**EXHIBITION OF ENVIRONMENTAL ASSESSMENT FOR
HORNSBY KU-RING-GAI HOSPITAL, MENTAL HEALTH UNIT MP08_0227**

I refer to your letter dated 21 July 2011 regarding the above application. The Department of Transport (DoT) has reviewed the *Environmental Assessment* and provides the following comments:

Figure 8: Car Parking

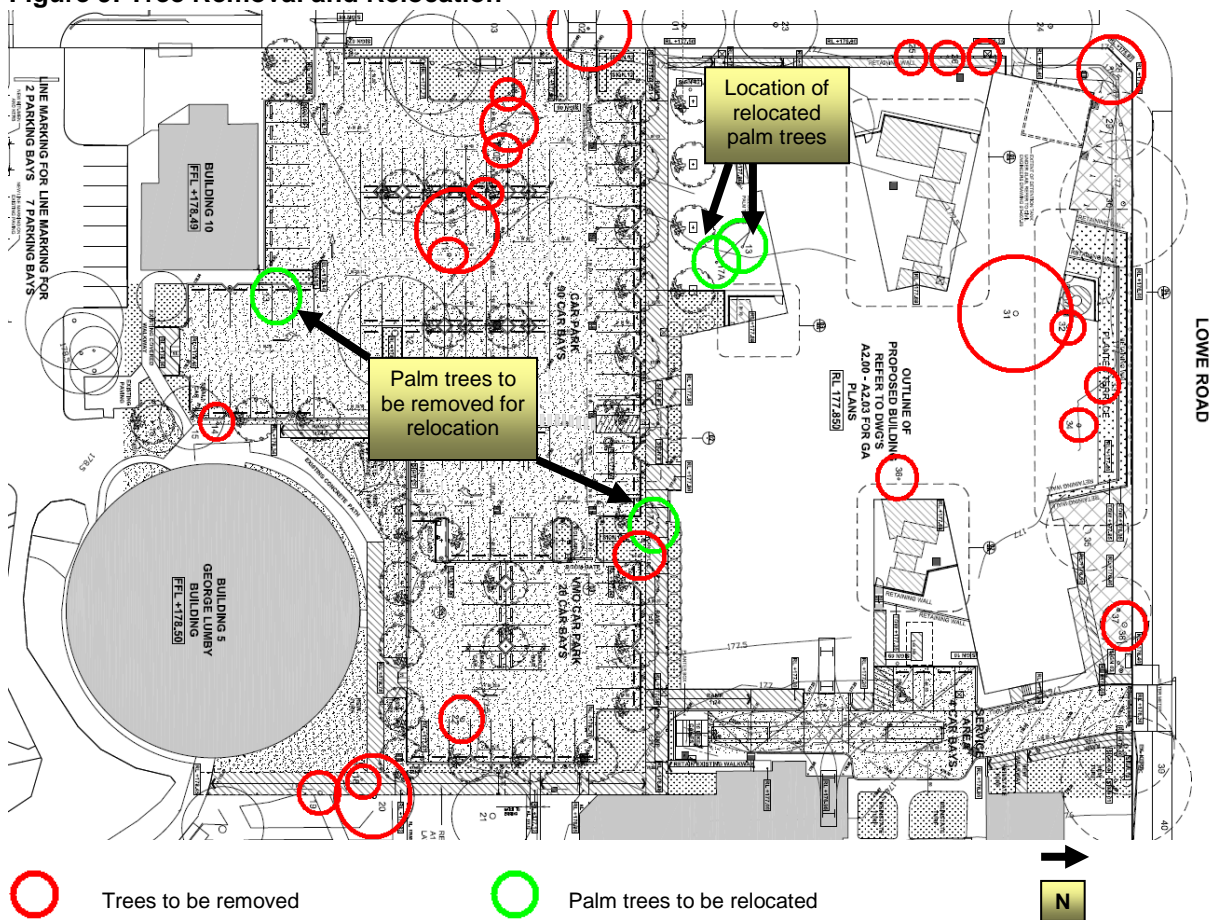
- DoT notes the design of suitable bicycle parking and storage areas is to be provided prior to construction as listed in the draft Statement of Commitments. DoT recommends that bicycle parking should be provided at-grade near entrances, in a weather protected location and subject to casual surveillance. Provision of bicycle parking should be included as a condition of consent;
